**Culburra Beach 2540**

### **Submission on West Culburra Concept Proposal: concerns and suggested improvements (Application No. SSD 3846)**

**February 2021**

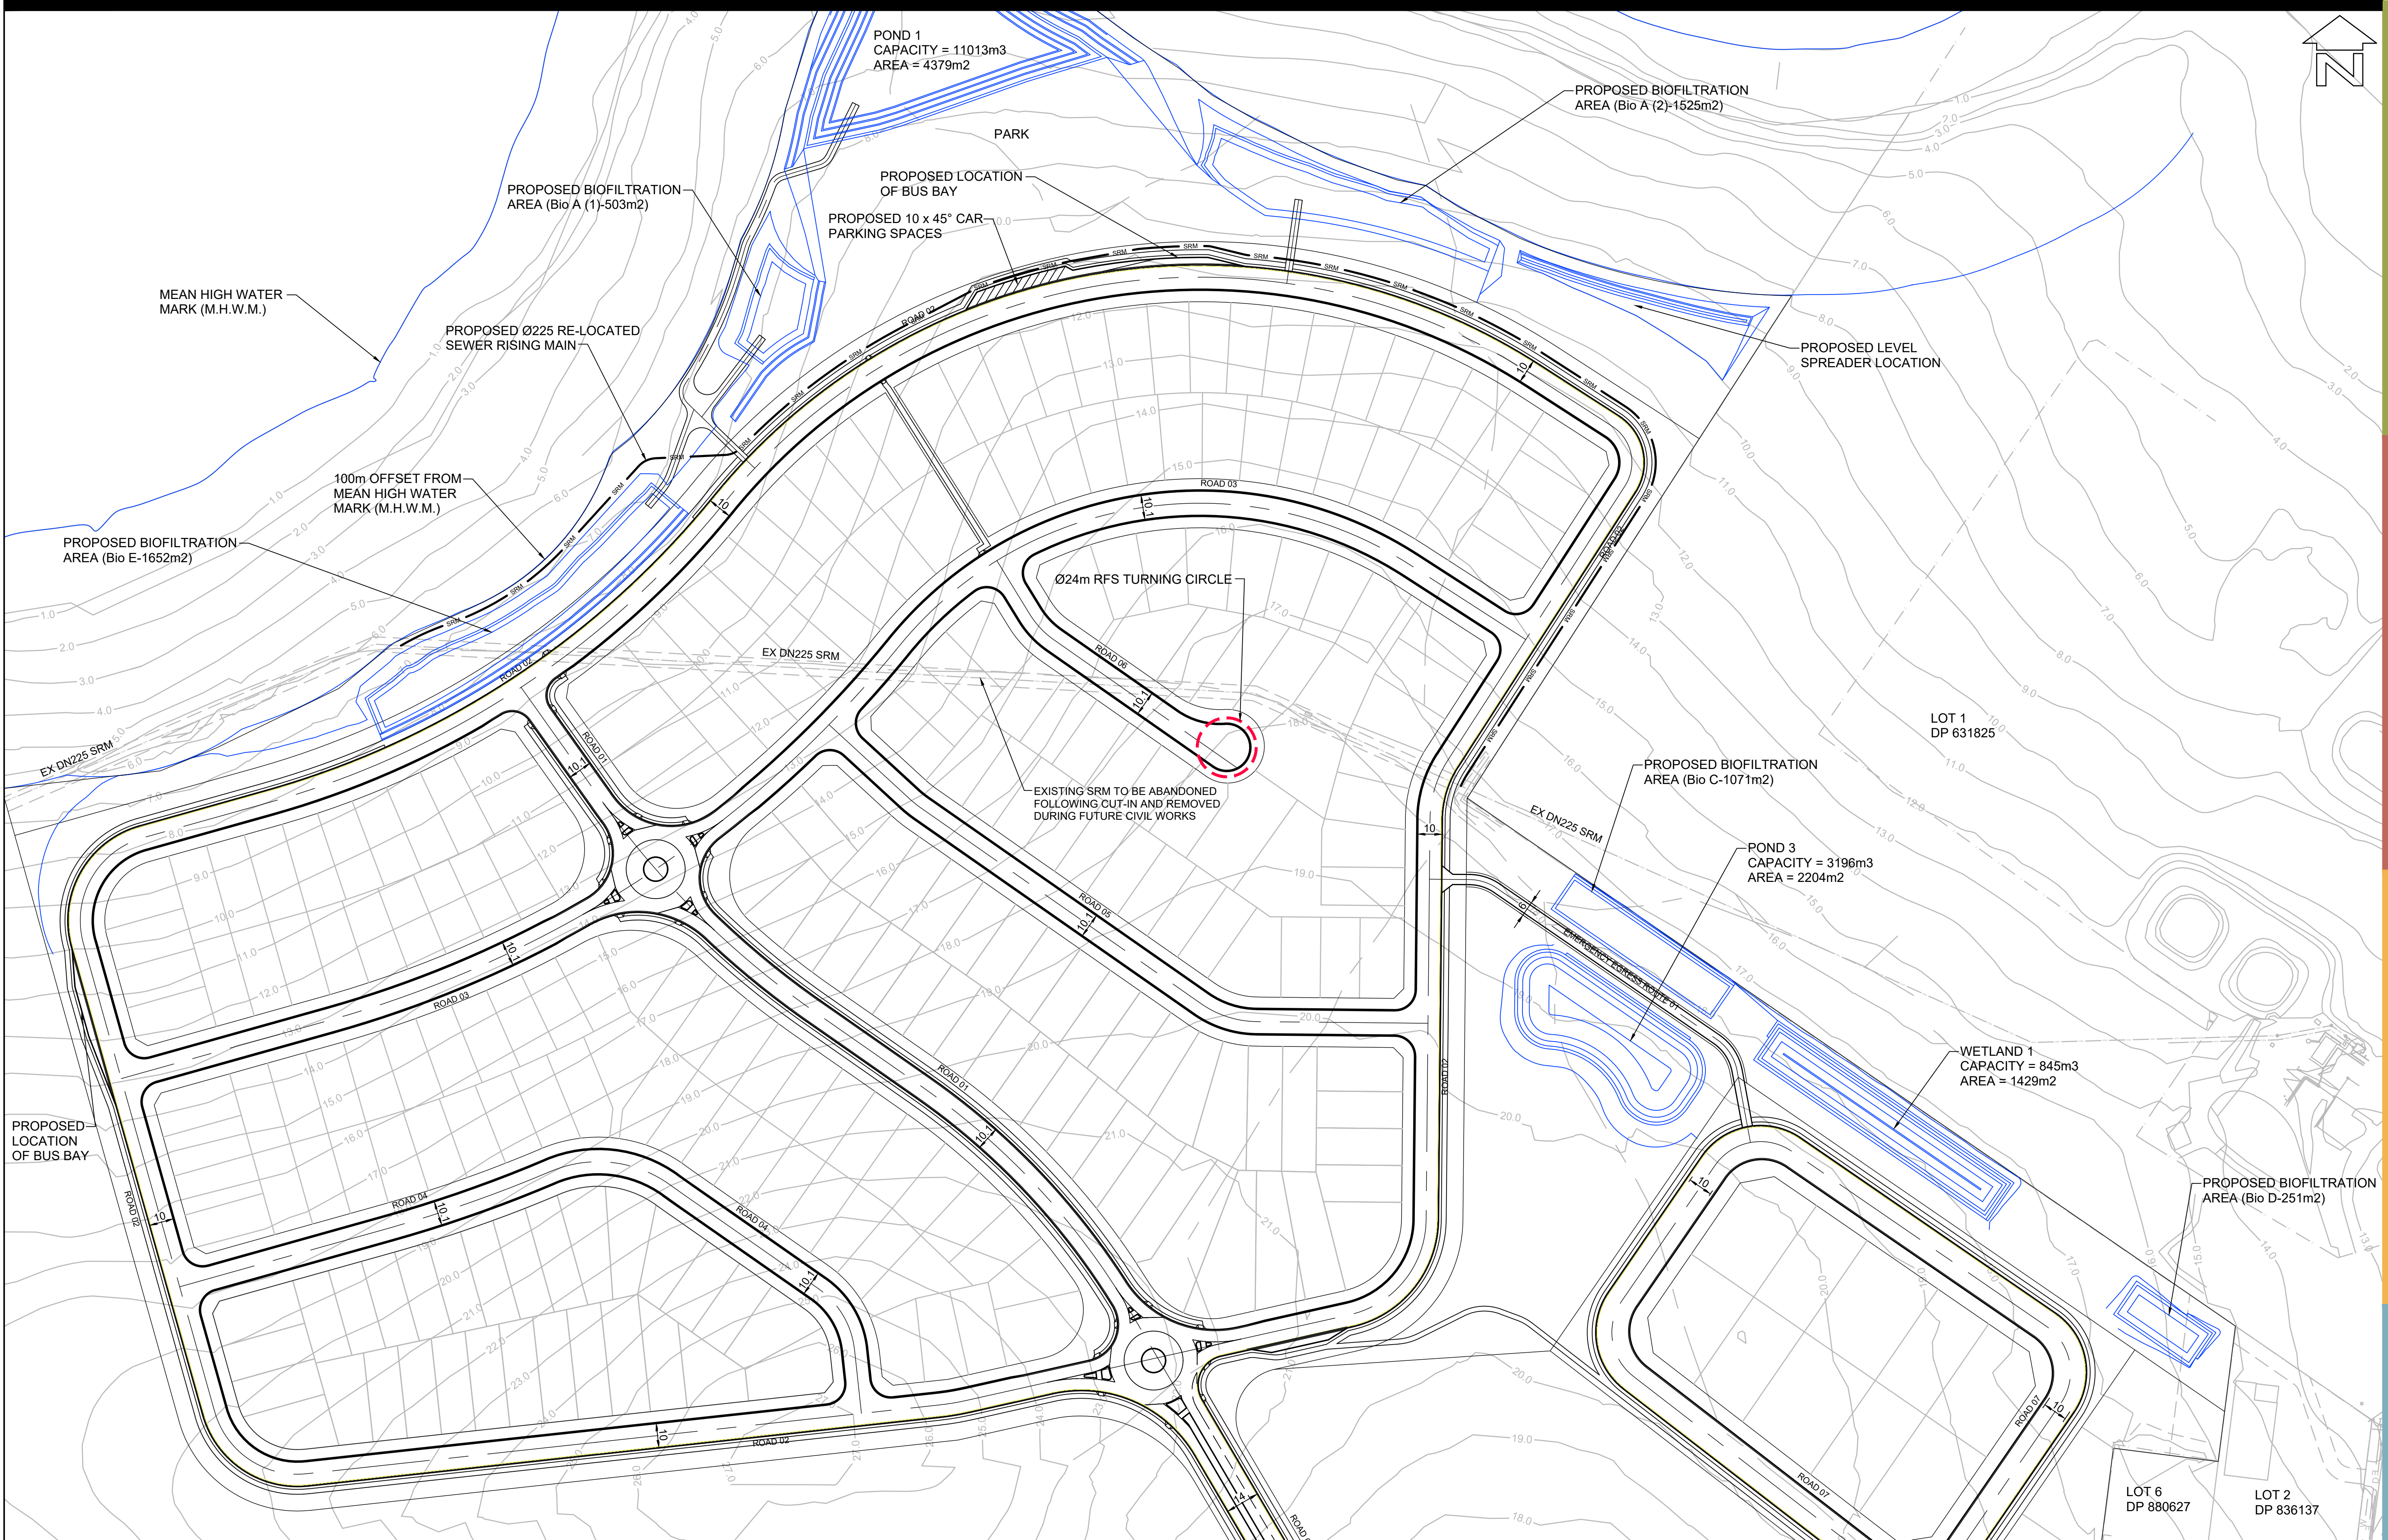
Having said that, the proposed subdivision layout is contrary to current urban planning thinking, the current State Government priorities and the DGRs for the original DA. There is little evidence in the Reports on the requirement that the proposal is to consider the Heart Foundation's "Healthy by Design" publication (Director-Generals Requirements – DGR – 12.2). This is a guiding document across Australia for 'Healthy Planning' (an area that I have been deeply involved in for a decade). In fact, the EIS states that '...this assessment has not specifically addressed the design considerations within' Healthy by Design (61). It is not true that the revised plan 'has incorporated optimal design approaches that encourage active living' (61), particularly within the subdivision. In these COVID times walkability and active living are paramount.

The subdivision is bland, old-fashioned and mono, especially given the current wealth of advice provided on the 'green web', 'urban heat island' effects and walkable neighbourhoods from, among others, the NSW Government Architect. Why is it so bland?

As a result, there are a number of specific issues with the subdivision layout:

- This is not a walkable neighbourhood. Walkable neighbourhoods promote everyday activity, not satisfied by the waterfront park or minimal through-site links shown on the plans. Consider the southern-most lots. Cars will dominate.
- There is no central 'hub' as a community meeting place
- The lack of an internal open space network. Quality open space should be provided within the subdivision, not just the reserve. A network, with a number of passive and active recreation/ social options should be provided. There is not one open space area within the subdivision. Council's LSPS Planning Priority 1 promotes 'new suburban areas with high quality open space ....' (LSPS: 25).
- All up, the subdivision is an overdevelopment, aiming to maximise lot yield at the expense of open space/ walking connections for all lots.

At least, prior to any concept plan approval, the proponent should delete the poorly located lots (and many of the culs-de-sac), build-in internal open spaces and a pedestrian/ green network.

PRELIMINARY INDUSTRIAL PRECINCT LAYOUT PLAN

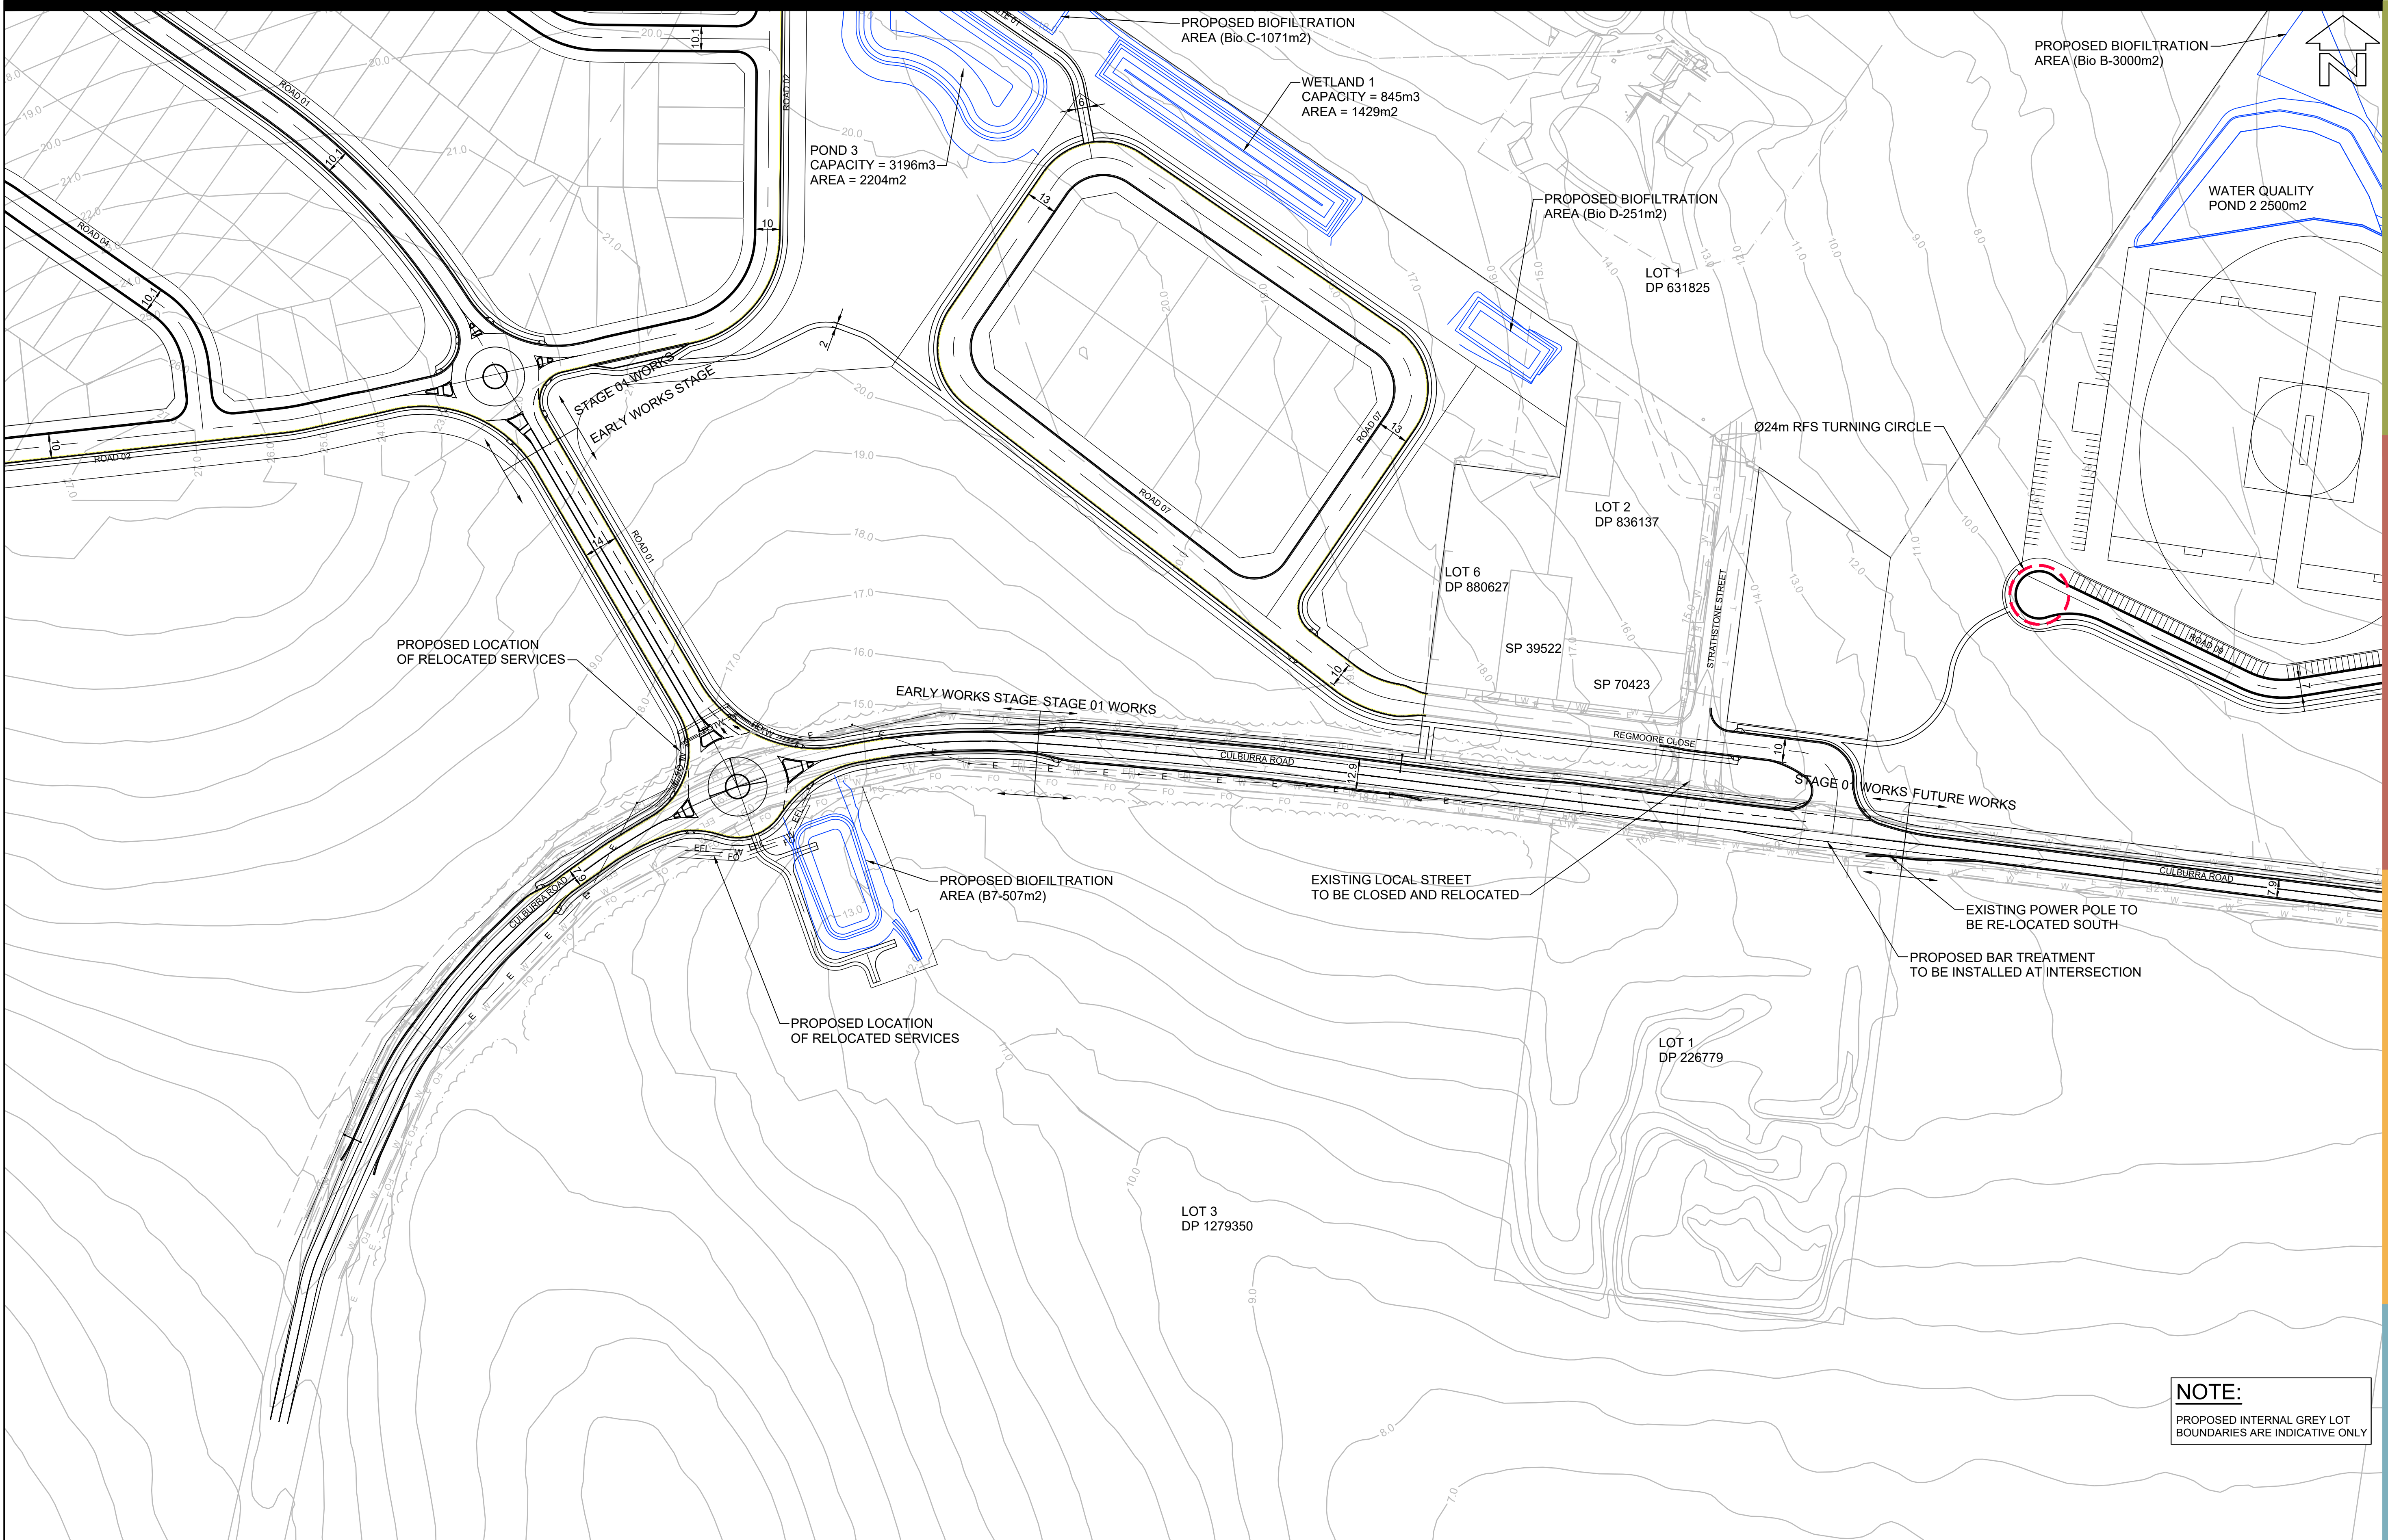
The draft Illawarra Regional Plan and Council's LSPS favour South Nowra for industrial growth. The LSPS adds the Jervis Bay-St. Georges Basin area and Ulladulla (LSPS, Planning Priority 9: 41).

Why would tradesmen and residents outside of Culburra access this area in preference to South Nowra (e.g. the brand-new mega Bunnings). Is it to cater for the needs of the various trades as the staging of the project unfolds? If taken-up, will it be dominated by self-storage units.
